Application Ref:	3/2025/0088			 Ribble Valley Borough Council www.ribblevalley.gov.uk
Date Inspected:	02/04/2025	Site Notice:	26/02/2025	
Officer:	MC			
DELEGATED ITEM FILE REPORT:				APPROVAL

Development Description:	Variation of condition 2 (approved plans) of planning permission 3/2022/1165 for proposed refurbishment of existing farm house, conversion of existing attached and detached barns to create three new dwellings, conversion of outbuildings for associated residential use and external works.
Site Address/Location:	Lower Reaps Farm, Whinney Lane, Mellor, BB2 7EL

name proposed - plans unit no.3 and no.4

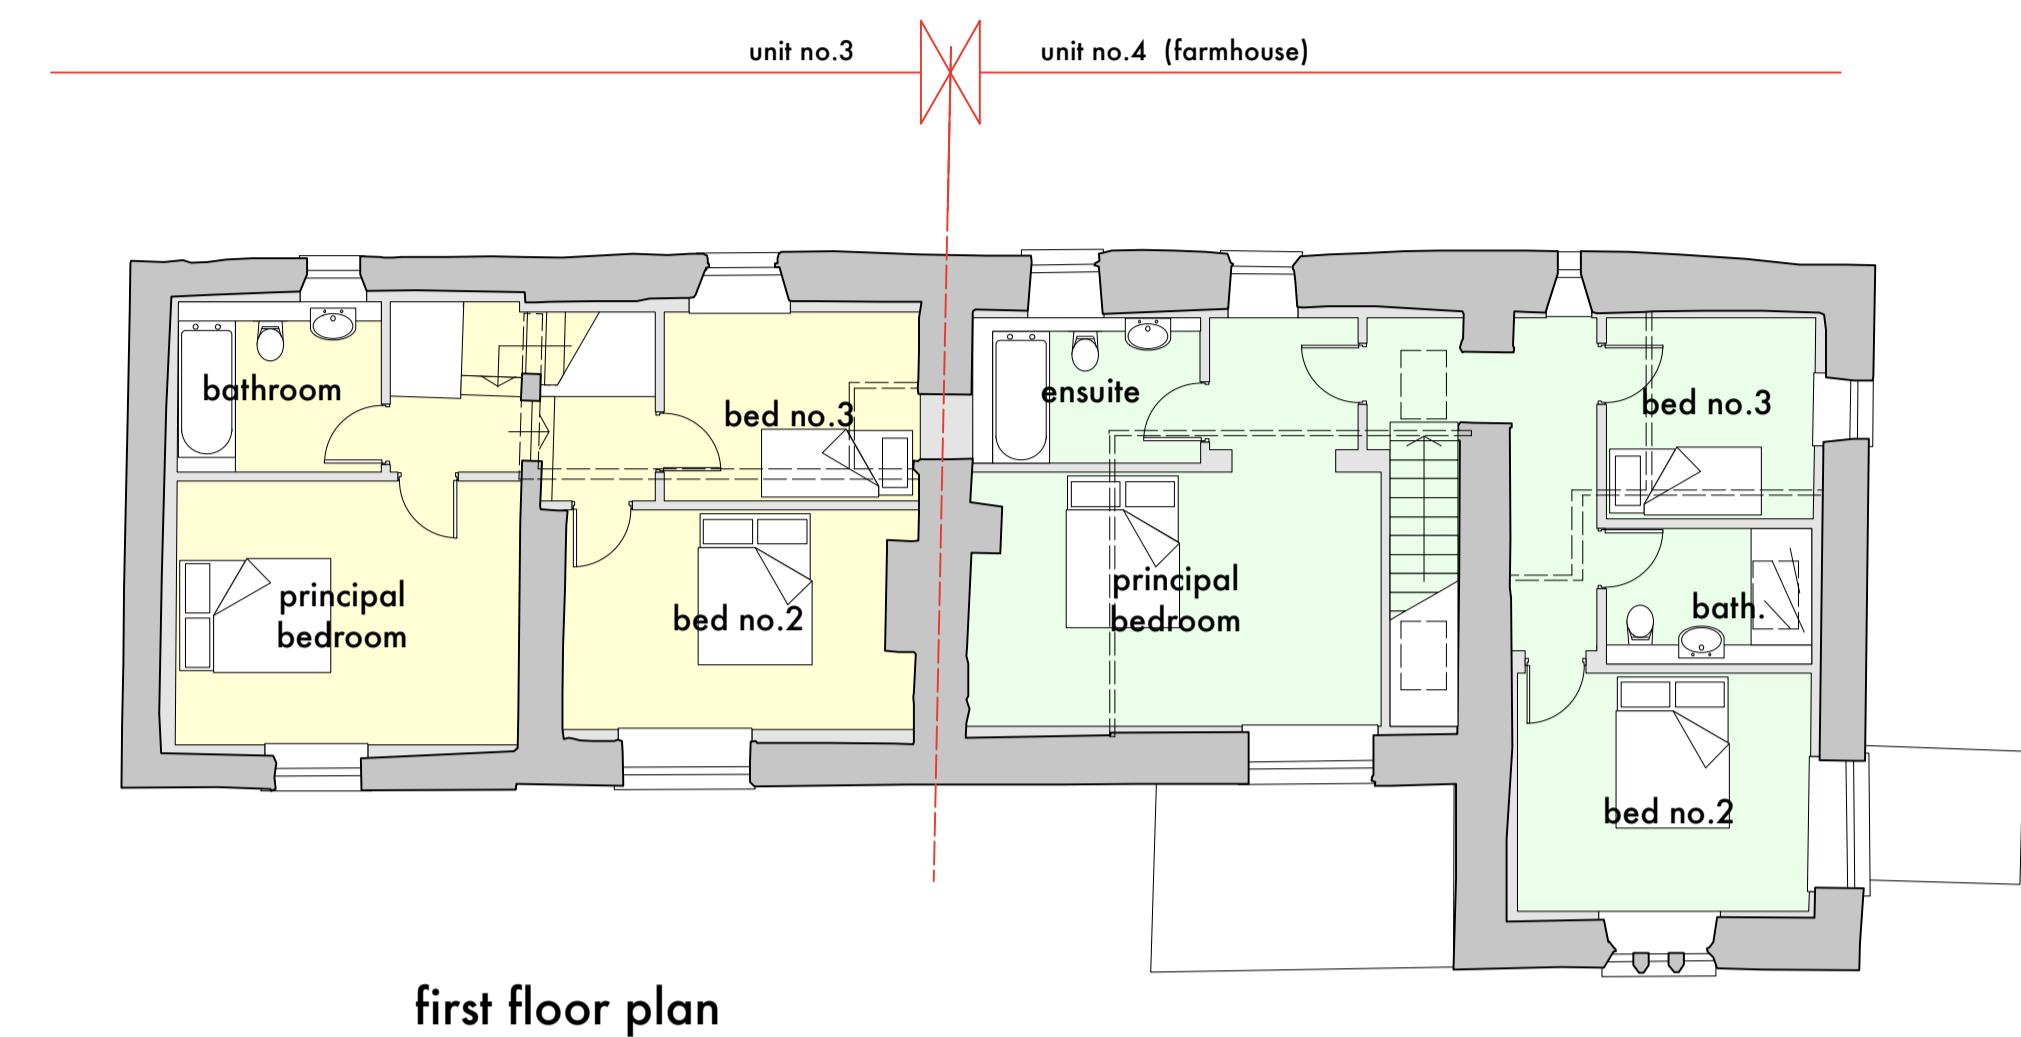
They raise no objection to the internal alterations which would be minimal and would mainly affect recent stud partitions, and the staircase would be relocated, which they consider would be returning it to its original position. Growth Lancashire consider that the proposed internal amendments now address the historic entrance area which allow the original rooms to be re-established.

farmhouse - north elevation

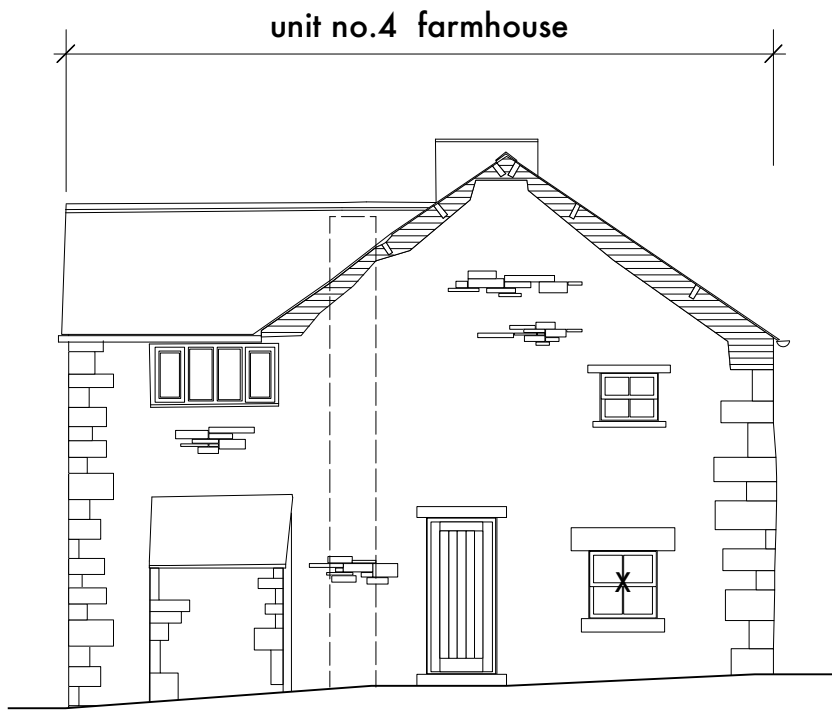
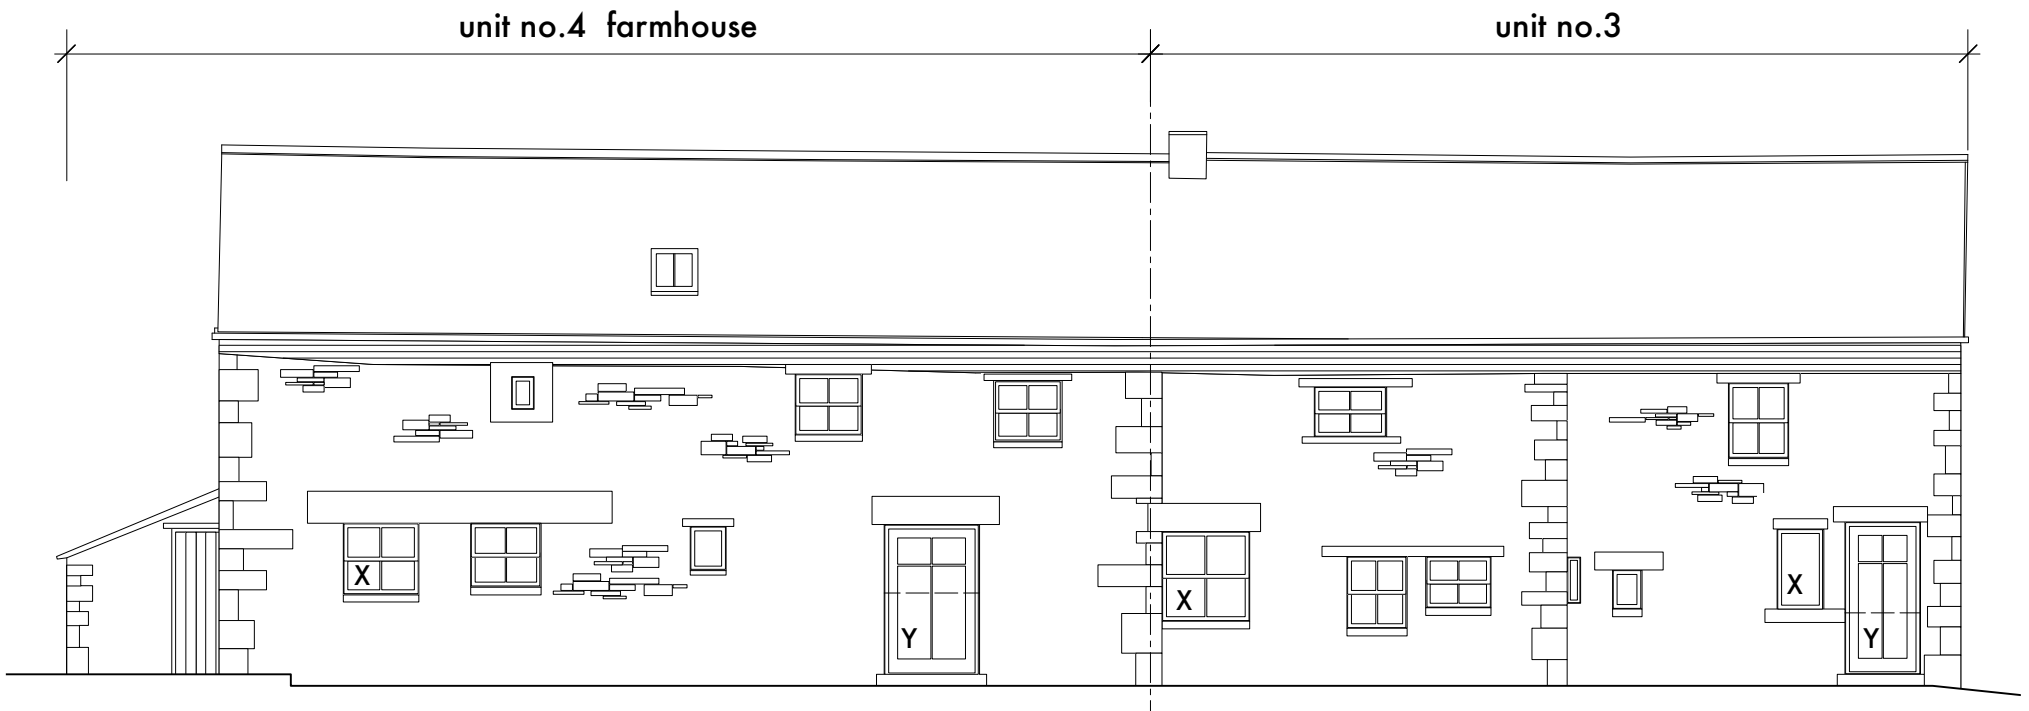
To the north elevation, the two window openings that are to be lengthened to form doors would now have doors containing less glazing. Whilst the Heritage Officer has stated they would prefer that there was no glazing in these doors, they accept that the reduced amount of glazing is a more appropriate solution that will not result in any discernible harm and will help preserve the character of the listed building.

An additional opening proposed to unit 3 on the north elevation, appeared to be overly large in comparison with the host building. It has since been clarified that the openings are former openings. Therefore, the size of the proposed opening is determined by the original opening. As such, the Heritage Officer is satisfied that this is acceptable; however, any material details, should be secured via a suitably worded Condition.

outbuilding - east elevation

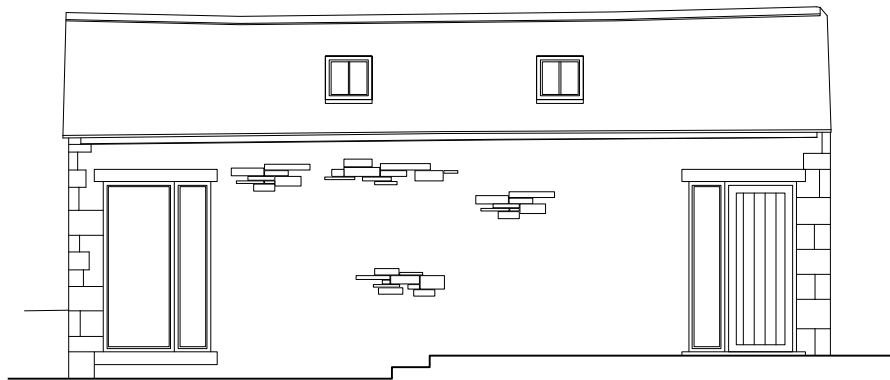
In respect of the chimney, the Heritage Officer is satisfied that this is a later addition, which does not match in materiality to the rest of the building and as such, it is acceptable for this not to be rebuilt.

farmhouse - south elevation

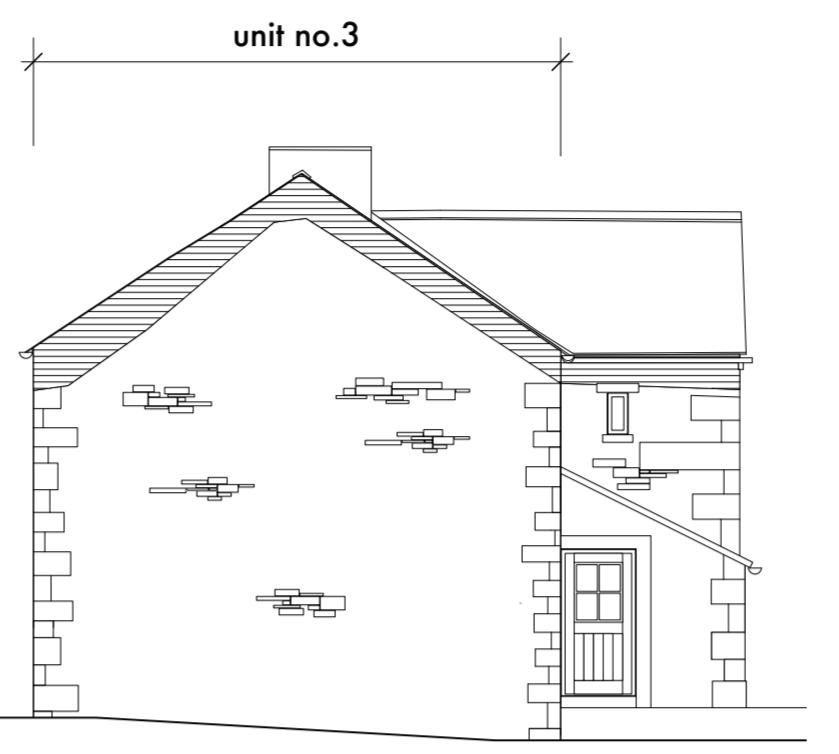
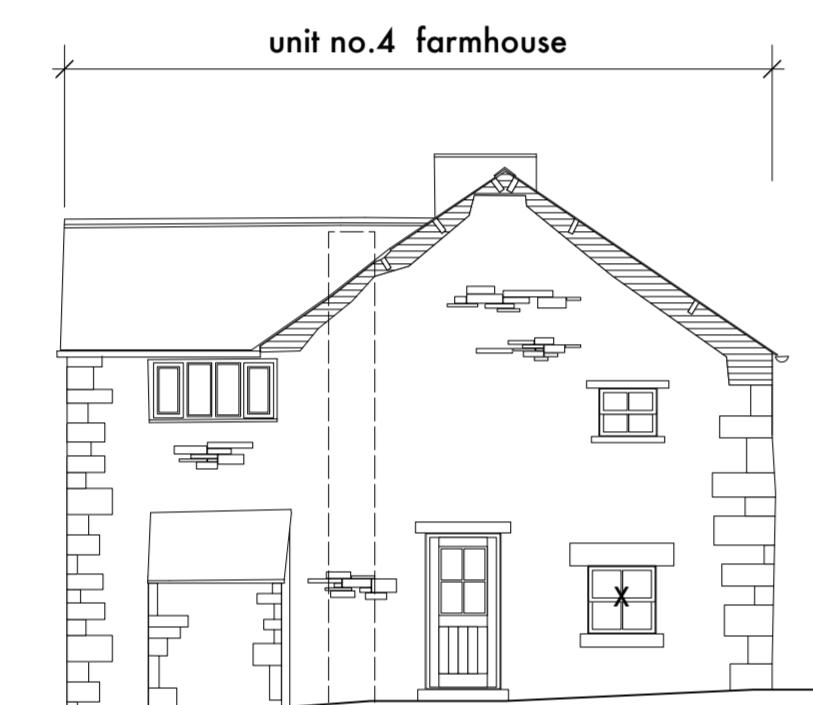
The proposed drawings now identify that the lean-to addition on the south elevation to the farmhouse (unit 4) will be finished in stone to match the farmhouse (walls to existing lobby to be finished in stone to match farmhouse). The Heritage Officer now finds this acceptable subject to a condition which requires a sample of the proposed stone to be submitted and approved by the LPA. In addition, the Heritage Officer notes that the additional proposed door to the west elevation of the outbuilding now appears to be proposed as partially glazed. Whilst the preference would be no glazing to the door, they accept the reduction in the amount of glazing as it is considered to be more appropriate that would not result in any discernible harm and is the same design put forward elsewhere on the farmhouse.
